18 April 2019

SF2017/037839; WST17/00033

SSD 14_6456: Narrabri Gas Project, Supplementary Response to Submissions (RtS)

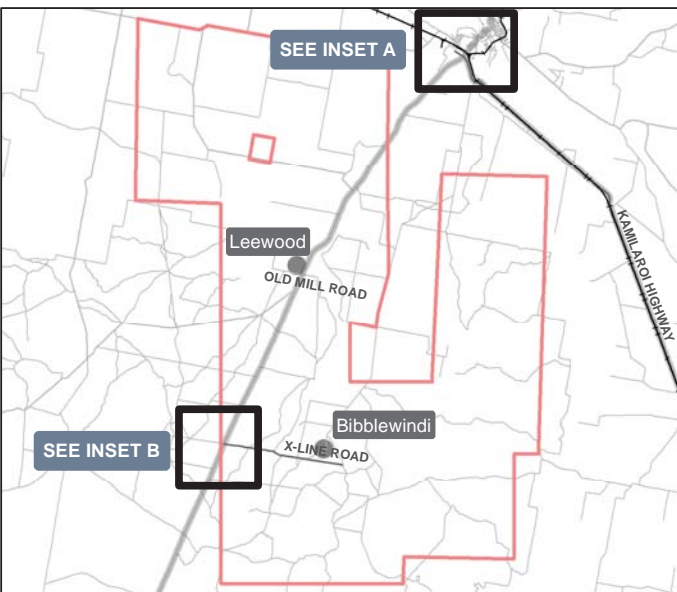
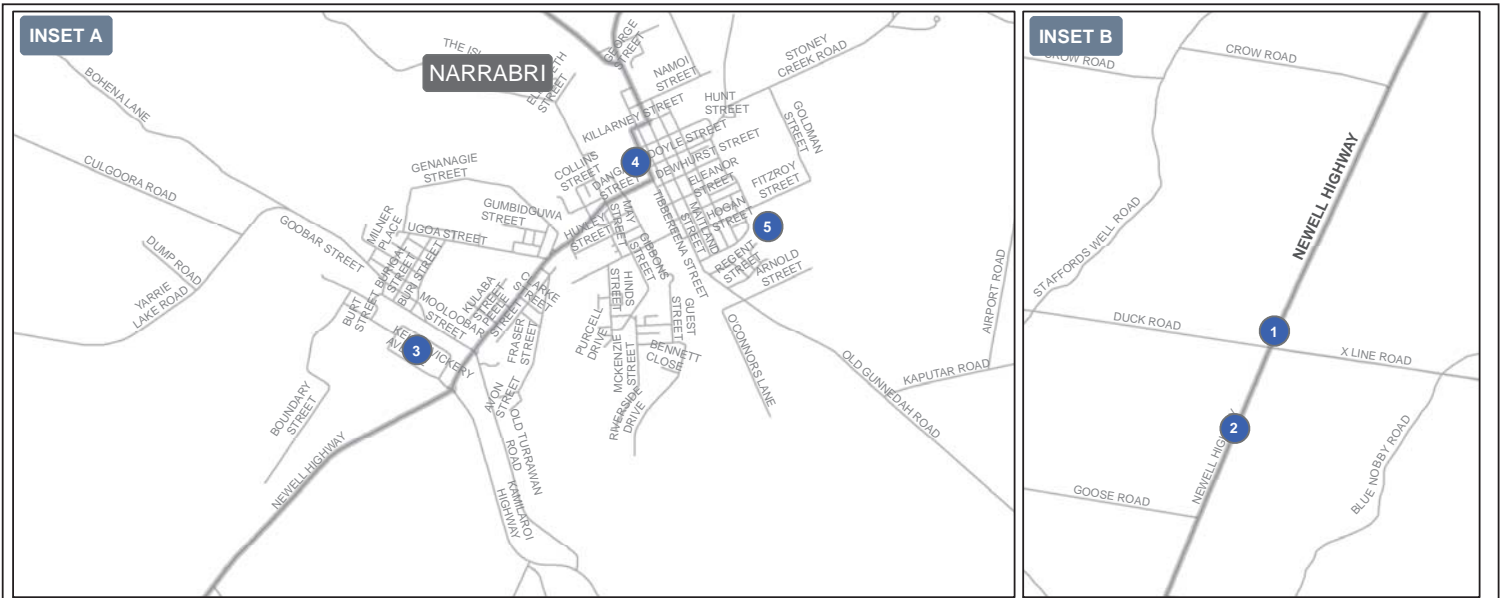
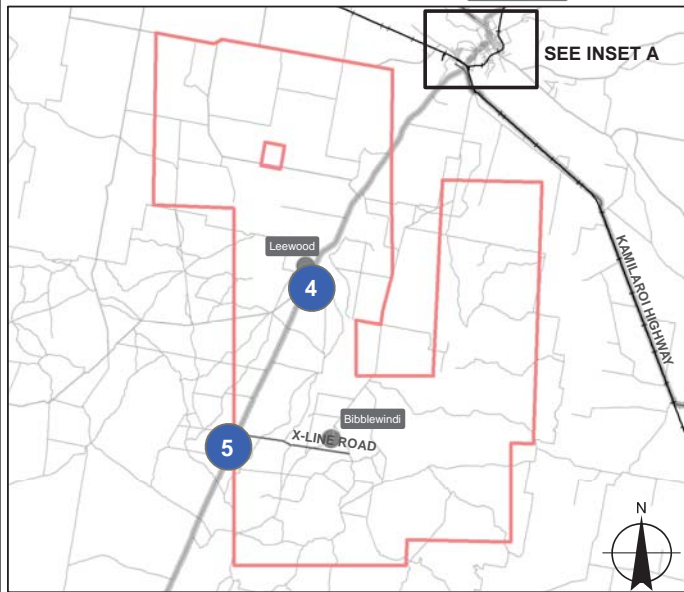
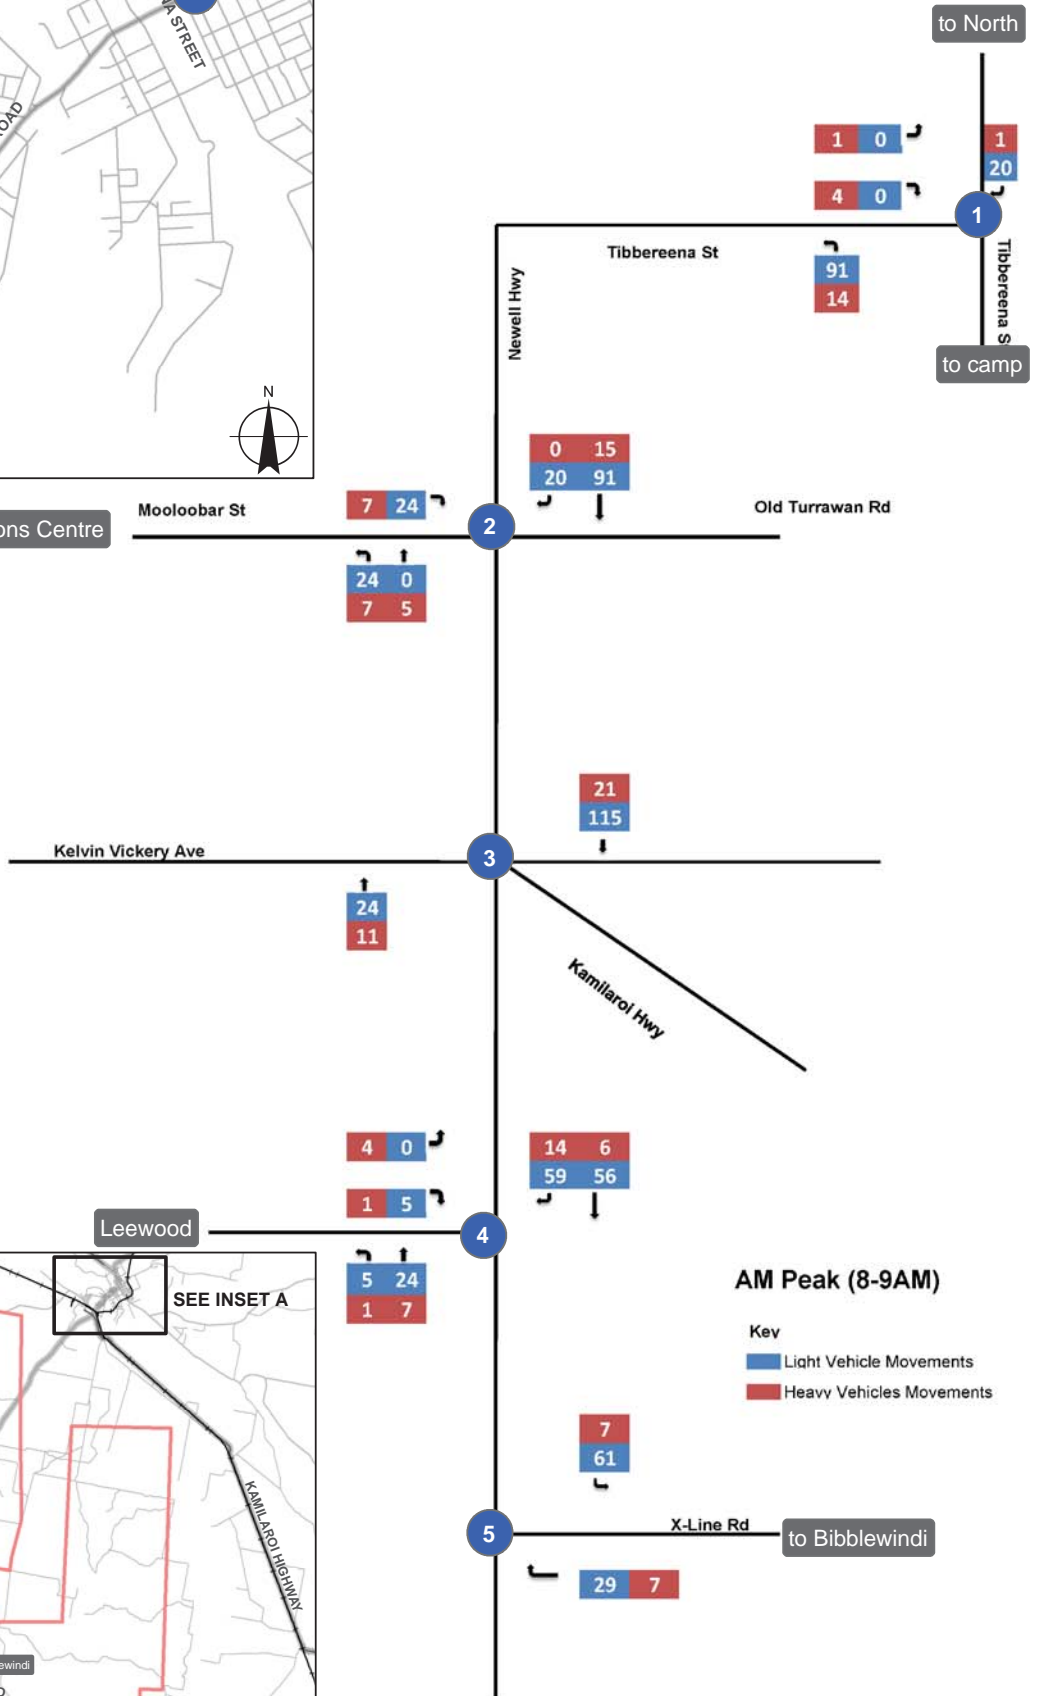
The Supplementary RtS has been reviewed. The proponent claims *the number of vehicles turning right into X Line Road is forecast to be minimal. As such a BAR treatment is not required.*

Roads and Maritime will require traffic data to make an assessment on actual turning vehicles before we can revise this requirement. A Basic Right Turn (BAR) is a minimum treatment, and will be required unless the proponent can provide turning volumes that demonstrate otherwise.
